My Ref: AW/267/15/HH-1

14th October 2015

Ref: **OBJECTION : AW/267/15/HH (68 The Drive, Craigweil)**

PROPOSED EAST ELEVATION 1:100

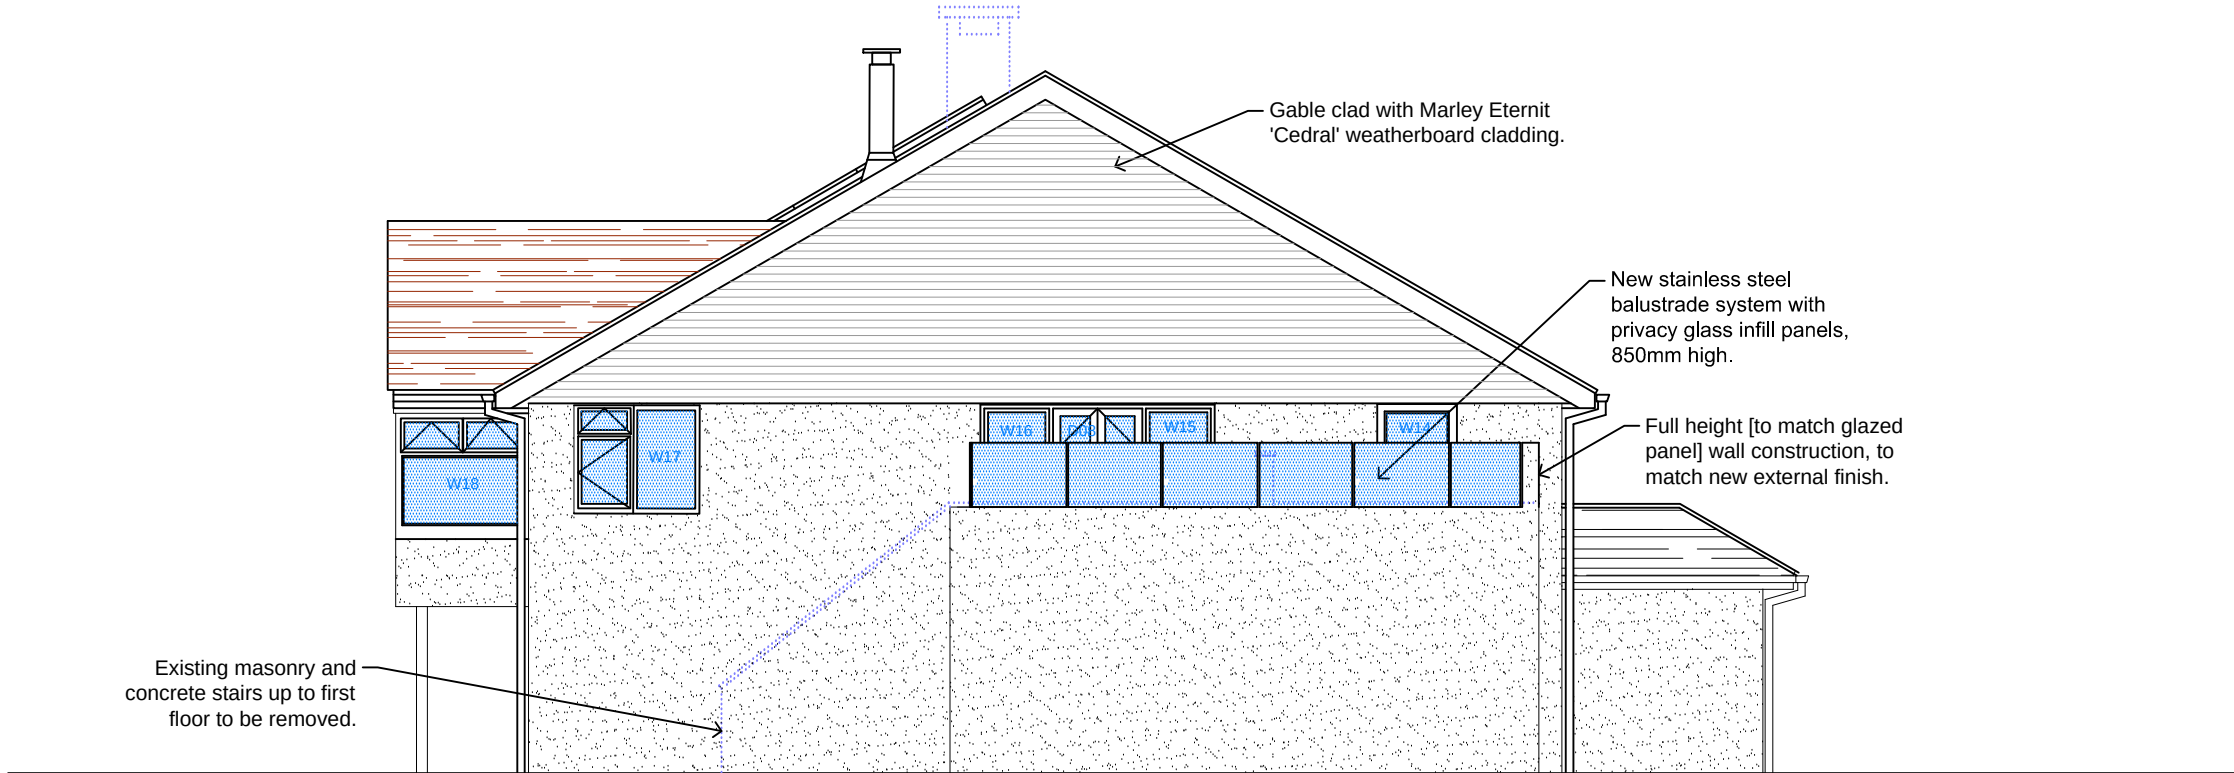
1. In a letter to the Council dated 27th August last, addressing AW/261/15/DOC, a Mr Mustion from Philips Surveyors says in response to meeting Condition 5 of the AW/344/14/HH Permission and I quote " I would like to confirm that the... The east terrace screening for privacy will be dealt with by way of raising the height of the existing parapet up to 1.8m **using insulated blockwork and rendered.**" Having spoken to the neighbours at No 70 The Drive, this alteration to solid, rendered blockwork is seen as a benefit to them, HOWEVER, in the plans **now before us** under AW/267/15/HH, that terrace is detailed as previously agreed in stainless steel with opaque glass panels. This plan was submitted to the District only 8 days after the statement that blockwork will be used. **So what is it we have proposed, is it glazed steel frames OR rendered blockwork??** These contradictory statement appears **FIVE TIMES** in the Design and Access Statement from the Agents Messrs. Philips. I have responded separately on this matter to the Council under AW/261/15/DOC, **but I consider it relevant to this current full Application AW/267/15/HH.**

2. Further now however, in the light of the privacy of both houses, **I fail to see the necessity of a balcony to the east side at all,** as the proposed balcony situated on the north-east of the building, will only receive sunlight in the early morning and gives no access to the garden below. **Its omission from a new house design will solve greatly the privacy issues with the occupants of No.70 The Drive, as their main bedroom is only feet away.**

3. All these factors concerning the proposals for replacing the existing side access to the east I still maintain must be **an unneighbourly and unacceptable intrusion** upon the residents of No.70 The Drive.

PROPOSED WEST ELEVATION 1:100

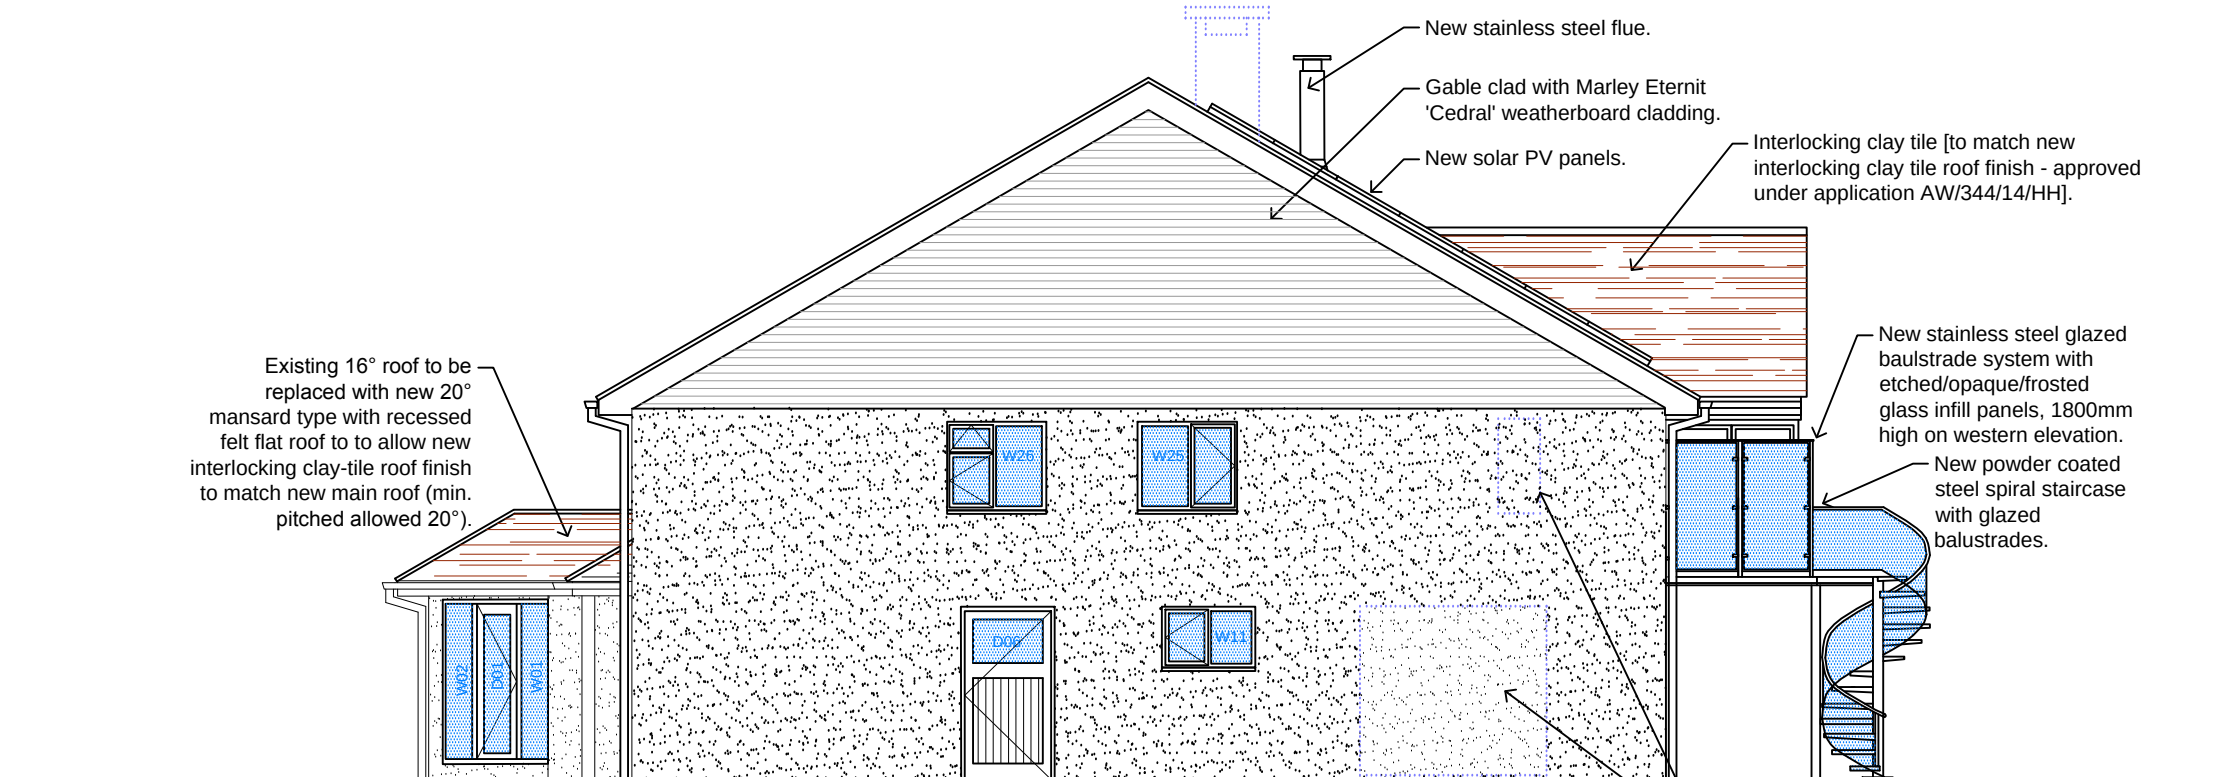
11. Similarly, with the proposed GREY Marley Eternit weatherboarding, this will directly face this original red/brown character property at No.66, completely out of context and an incongruous intrusion into the street scene.
